December 13, 2005

**Re: Status of Improvement Permit Application #05-5-13333
Crestview Lt 179**

CRESTVIEW Lot # 179

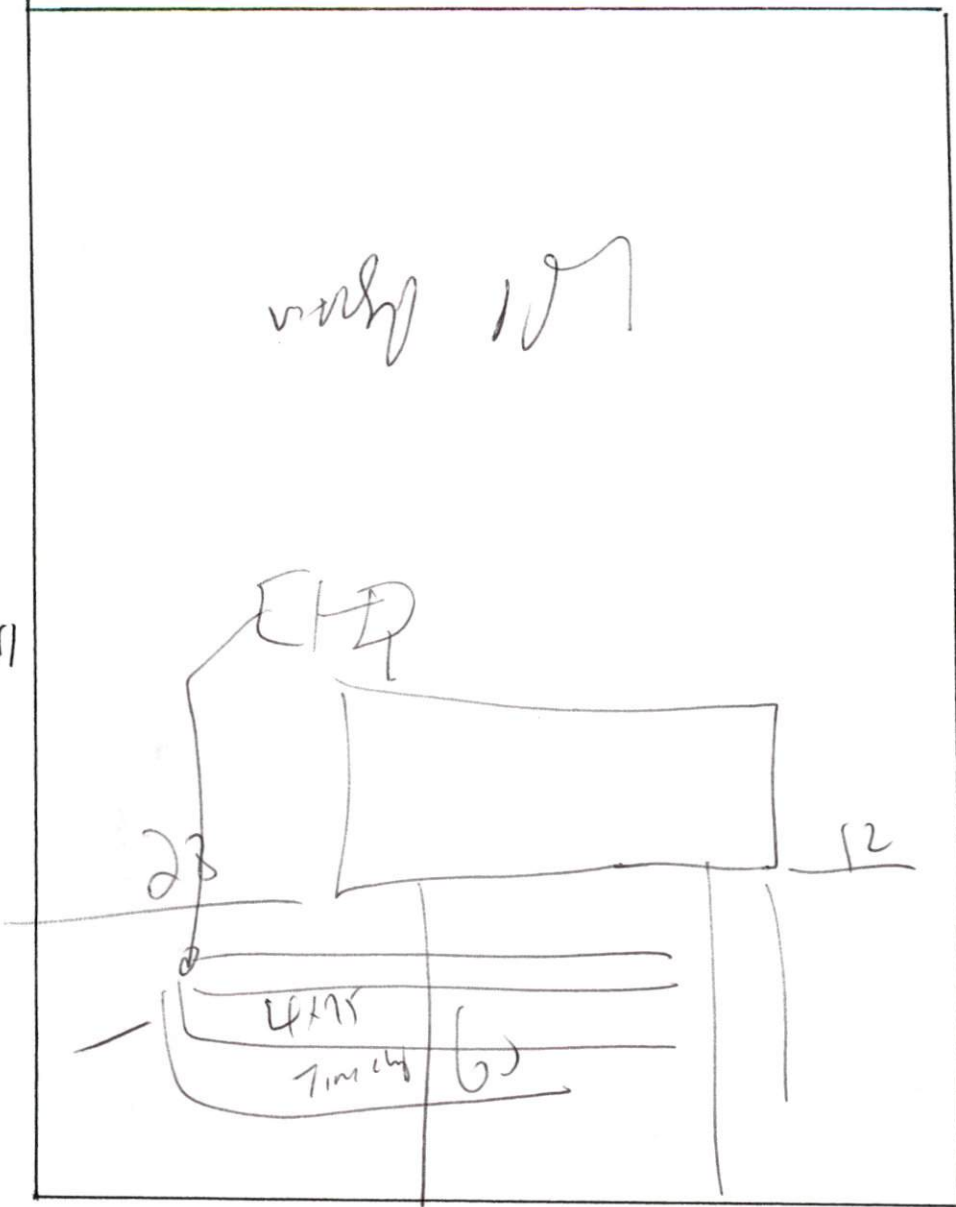
- 1. Property lines/corners not marked or labeled
- 2. House corners not marked or labeled
- 3. Directions not clear to property
- 4. Property needs brush or vegetation removed
- 5. Backhoe pits required
- 6. Other **Make changes to house location as shown. Submit new plot plan to Central Permitting.**
